STATE OF NORTH CAROLINA
DEPARTMENT OF TRANSPORTATION

Addendum No. 1

RE: Contract # C204123
WBS # 41582.3.1
FEDERAL-AID NO. STP-0211(021)
Brunswick County (R-5021)
NC-211 FROM SR-1500 (MIDWAY RD) TO NC-87

December 7, 2021 Letting

# INTERSECTION DETAIL AND DIRECTIONAL CROSSOVER INTO MDI MANAGEMENT, INC -L- STA 66+00.00

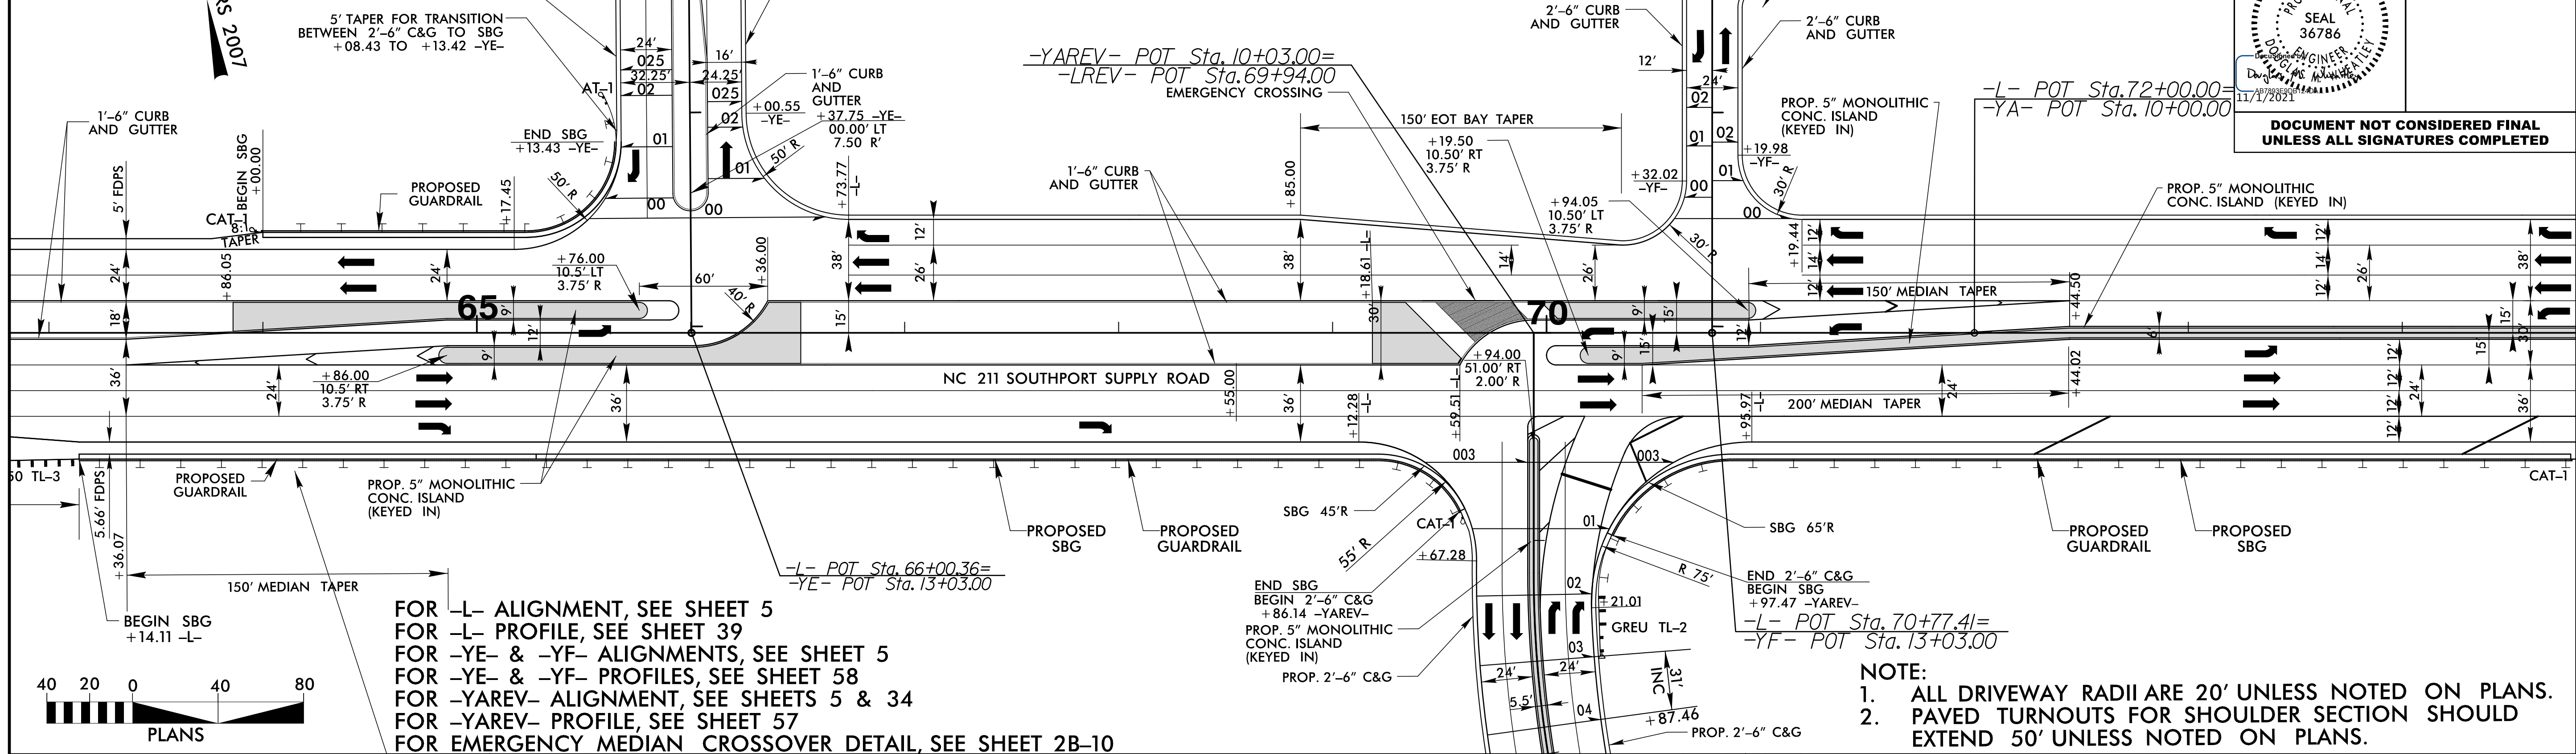
Sheet No.	Revision
2B-1	The intersection detail and directional crossover into the MDI Management, INC -L- STA 66+00.00. See plan sheets for more details (5 and 6).
2B-5	Bridge detail at intersection of L and YREV the third lane in the east bound direction has been striped out.
2B-7	Midway RD. / Middleton Blvd interchange overview sheet. (See Plan sheets 5 and 6)
2B-8	Y14E Begin station revised on overview sheet.
2B-10	Emergency vehicle access detail located on L has the following changes: 2 access removed on L and YA, the one on L shifted to a new location (STA 232+68.50) while the one on YA was removed since a RAB has been added in this location.
2B-11 (NEW)	Detail of roundabout, this sheet has been added with the addition of the RAB alignment.
2C-20 (NEW)	1'6" C&G to 2'9" C&G Transition Section Detail sheet added.
2D-1 thru 2D-3	Drainage Details updated.
3B-1	Guardrail updated on L between STA 63+14.11 to 78+92.16 on the RT.

PROJECT REFERENCE NO. <b>R-5021</b>	SHEET NO. <b>2B-11</b>
RW SHEET NO.	
ROADWAY DESIGN ENGINEER	
DOCUMENT NOT CONSIDERED FINAL UNLESS ALL SIGNATURES COMPLETED

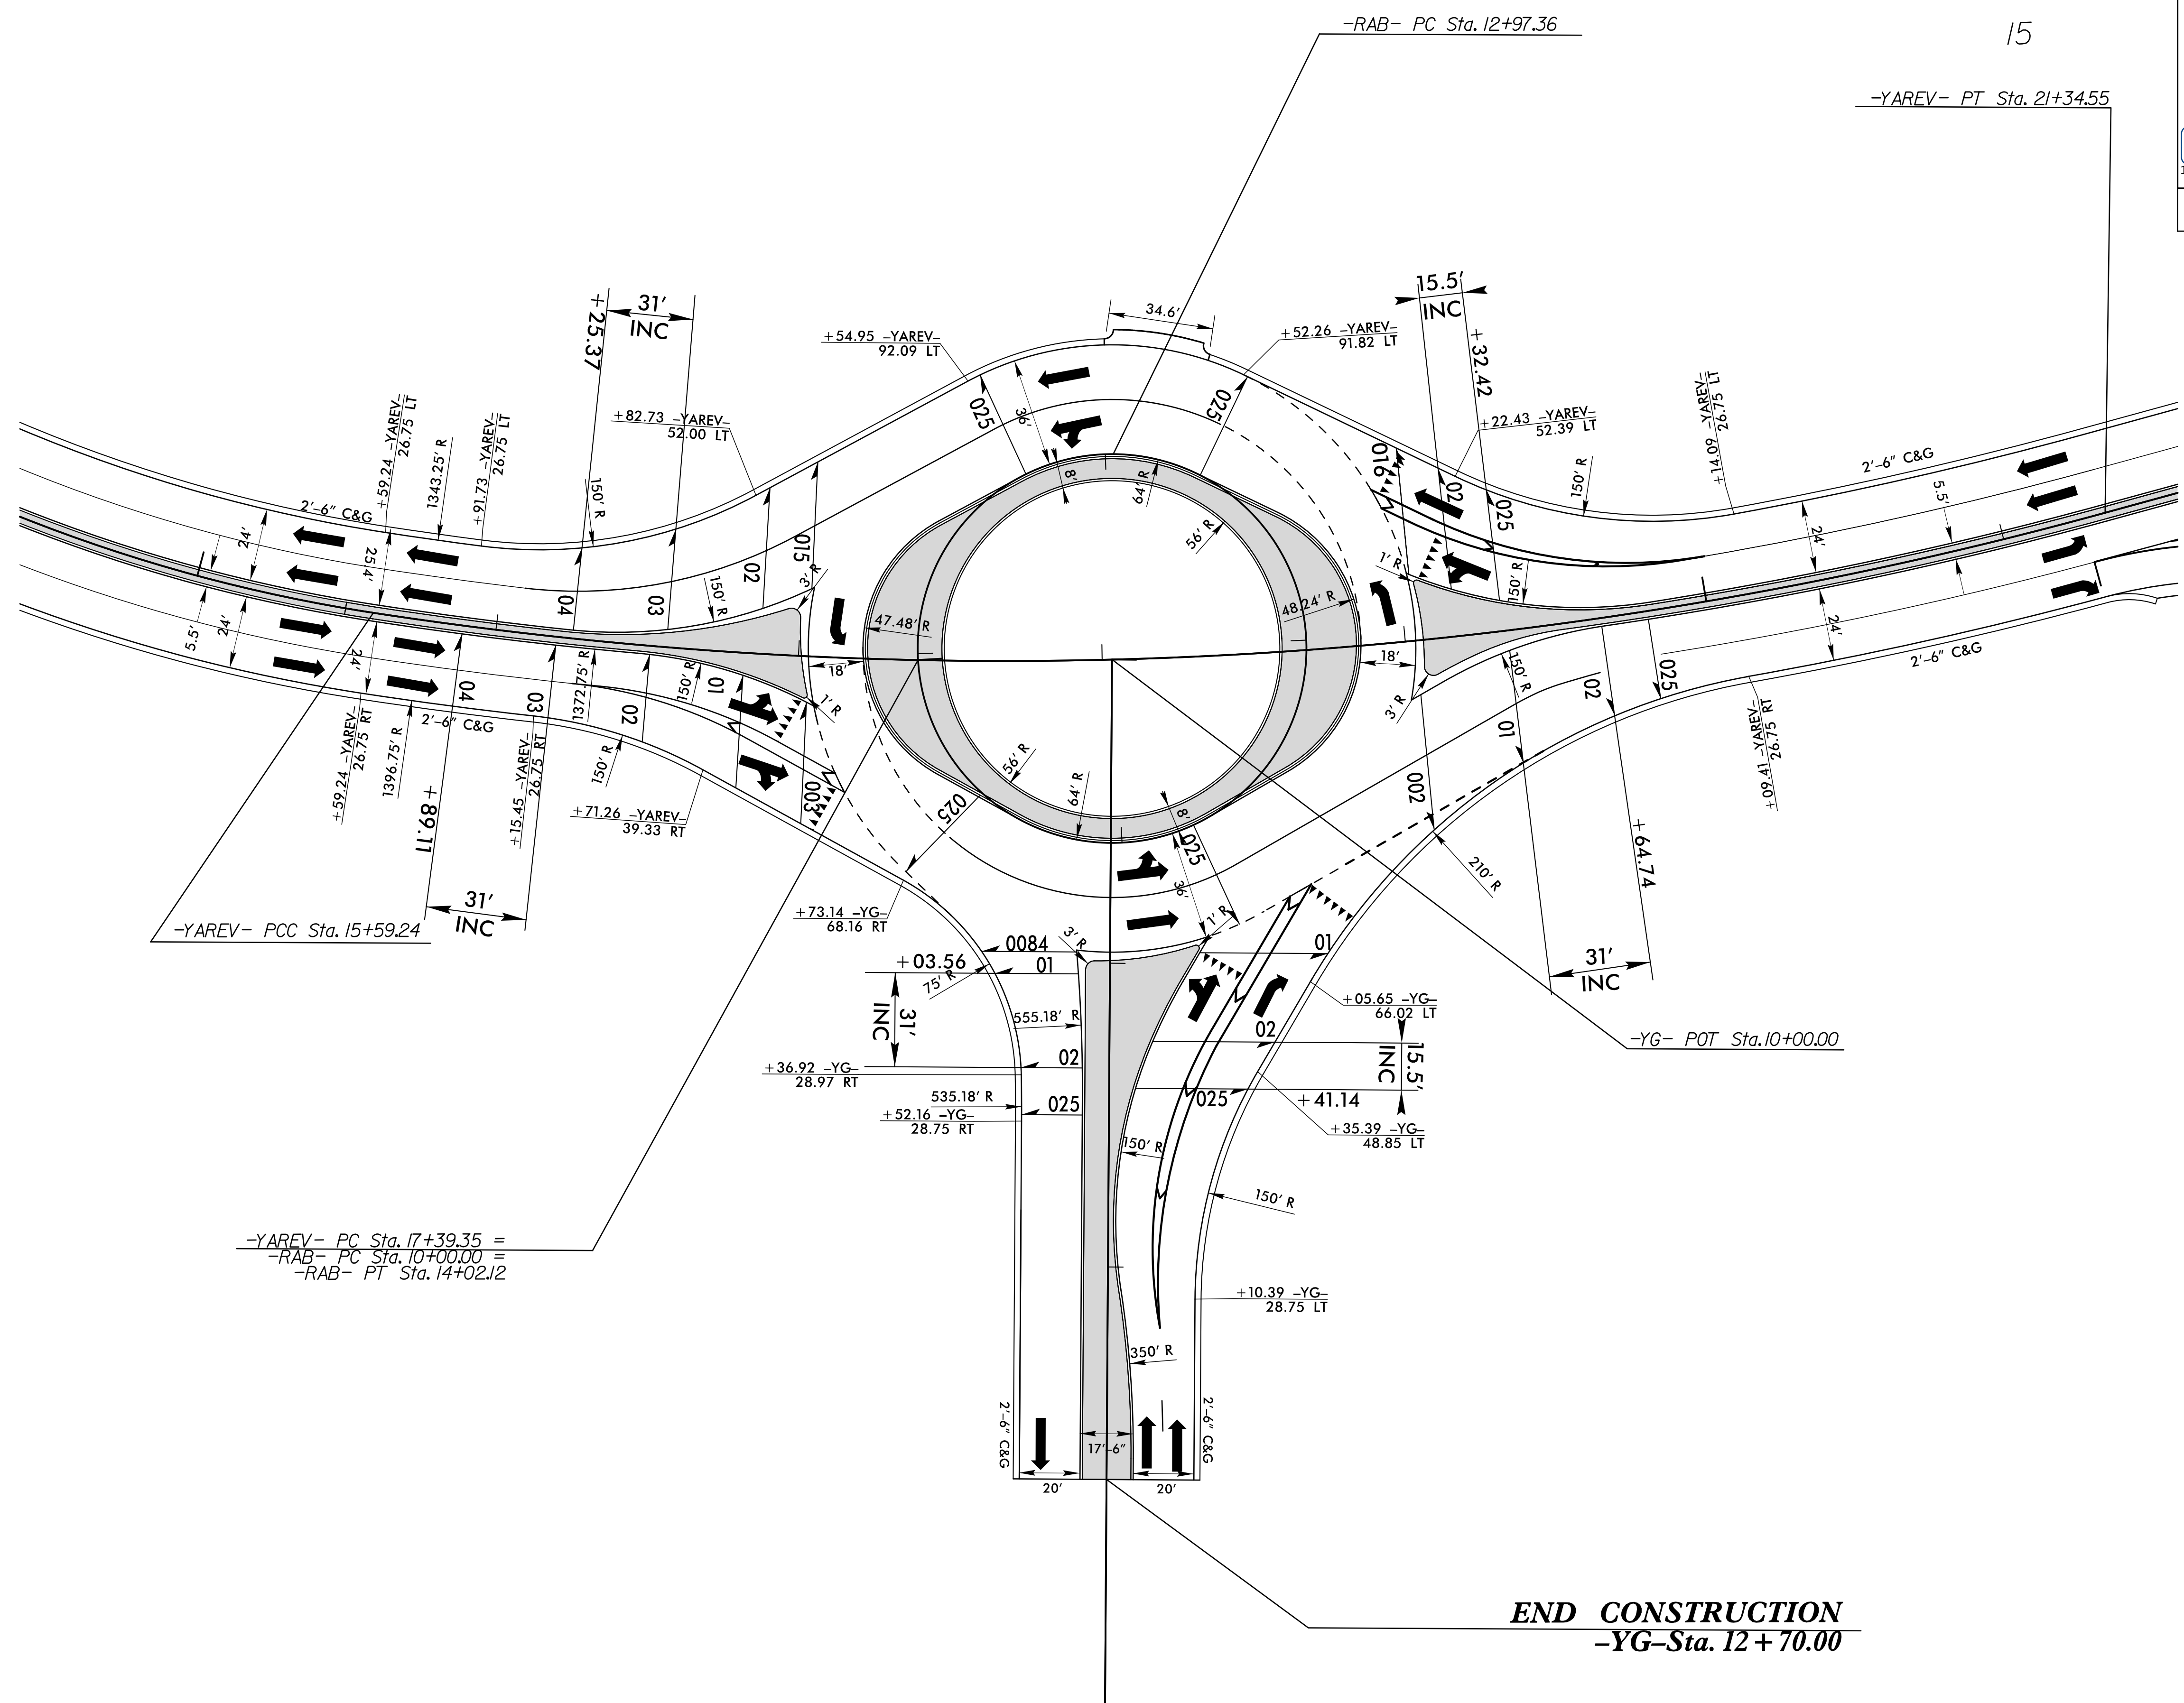
Sheet No.	Revision
1 (TSH)	Plan sheets 5,6,34 shifted slightly to include the new RAB area on YAREV. Alignments RAB, YG, and YAREV added. Two new proposed traffic signals added at LREV/YAREV and at the left over on LREV right before the YREV bridge. Letting date revised.
1A	The following sheets added: 2B-11, 2C-19, 2C-20, 3D-23, Profile sheet 71, all row sheets have updated numbers (RW0-xx), 8 sheets added to Utilities by Others, XSC sheets added to account for the new alignments. STD. Drawings added: 422.03, 840.03, 850.01, and 850.11
2A-1 thru 2A-16	R9 and R10 in the pavement schedule added on all typical sheets.
2A-5	Typicals 9 and 10 removed from this sheet as YA has been replaced with YAREV.
2A-16	Typical 56 added to this sheet.
2A-17 (NEW)	Typical 57, 58, 59 added. They relate to all new alignments that have been added with the addition of the RAB and its legs.
